KITTITAS COUNTY

MEMORANDUM

TO: All Staff
FROM: Justin Turnbull, County Surveyor 
DATE: April 21, 2021
SUBJECT: County Survey Review of CU-21-00003 Ryegrass LPL Expansion

FIGURE
 2-1

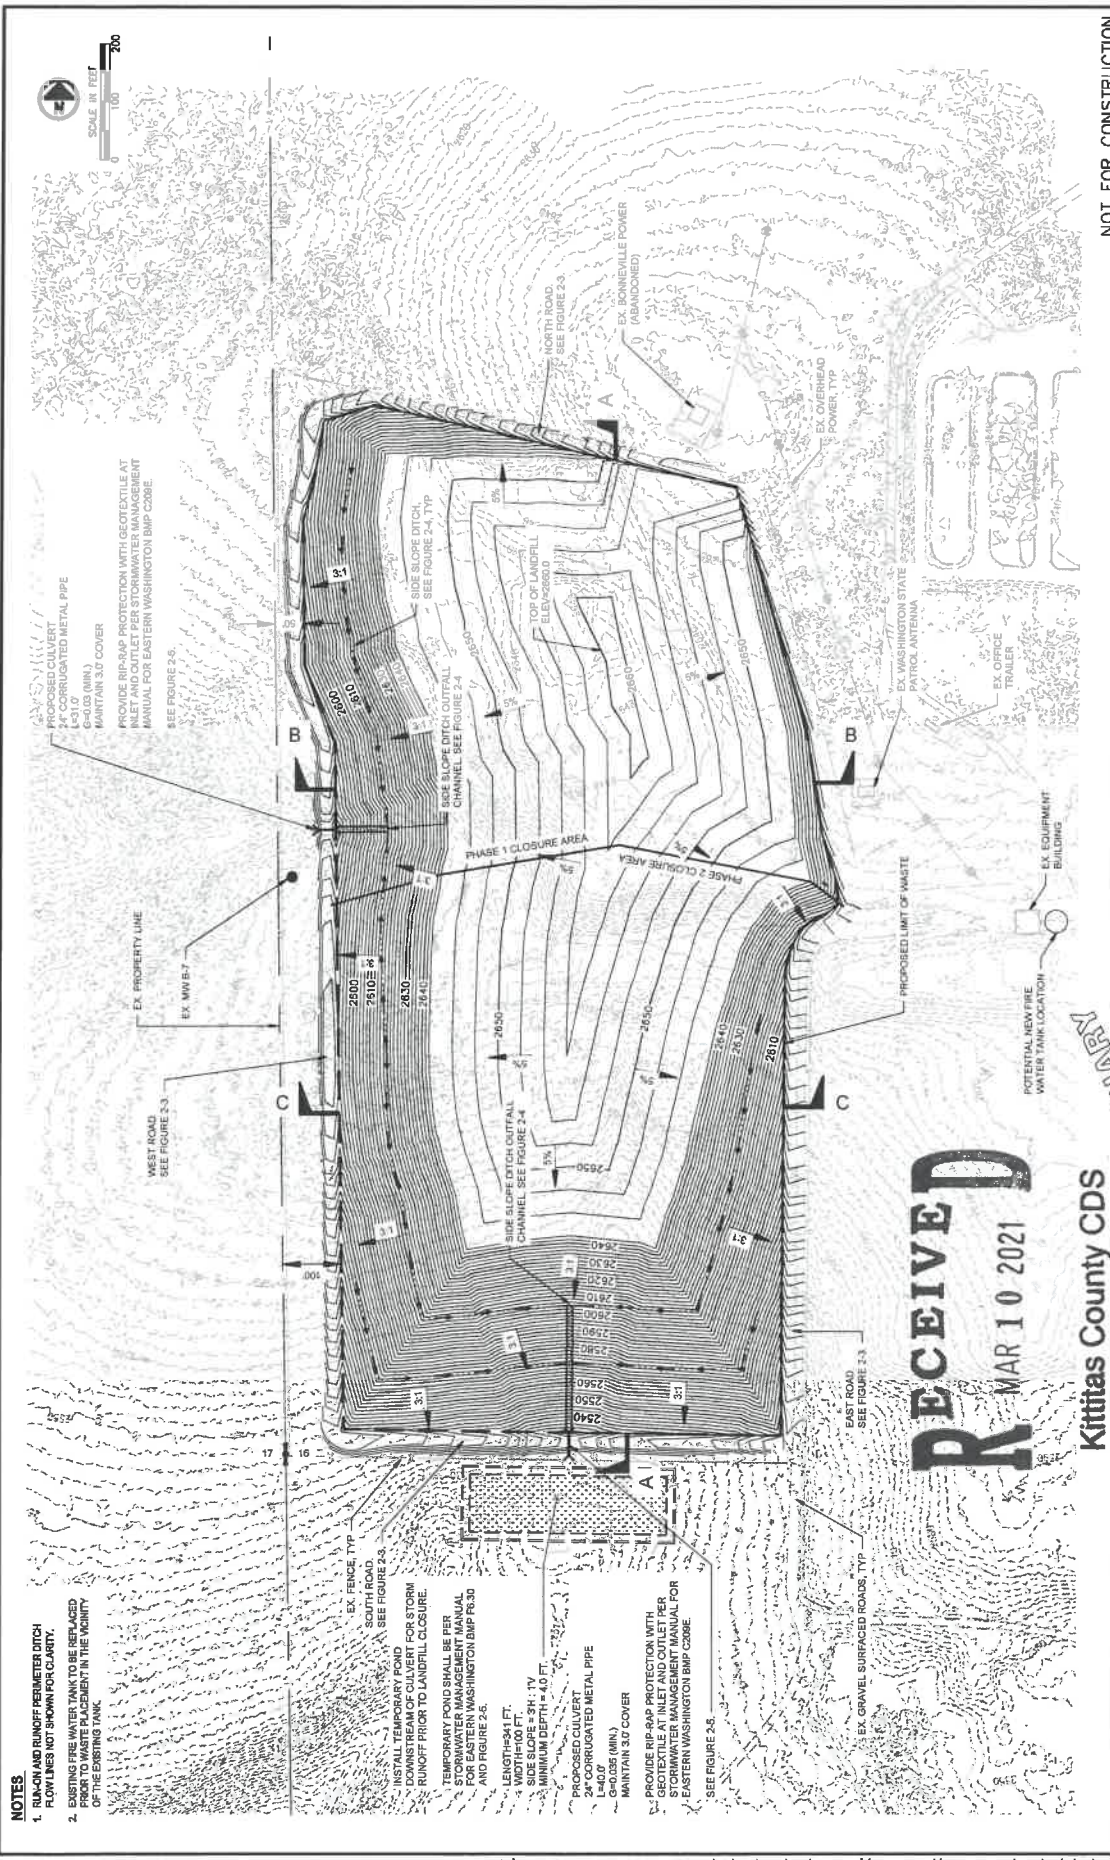
Please note the following survey comments are in reference to the site map only. All other aspects of the application are outside the realm of survey review.

1. The site map includes the Kittitas County Public Works title block. As public works is not involved in this application, I believe this should be Kittitas County Solid Waste.
2. In 2018, DNR introduced new topographic map standards, under WAC:332-130-145. Please insure all the elements addressed in this new WAC have been addressed.
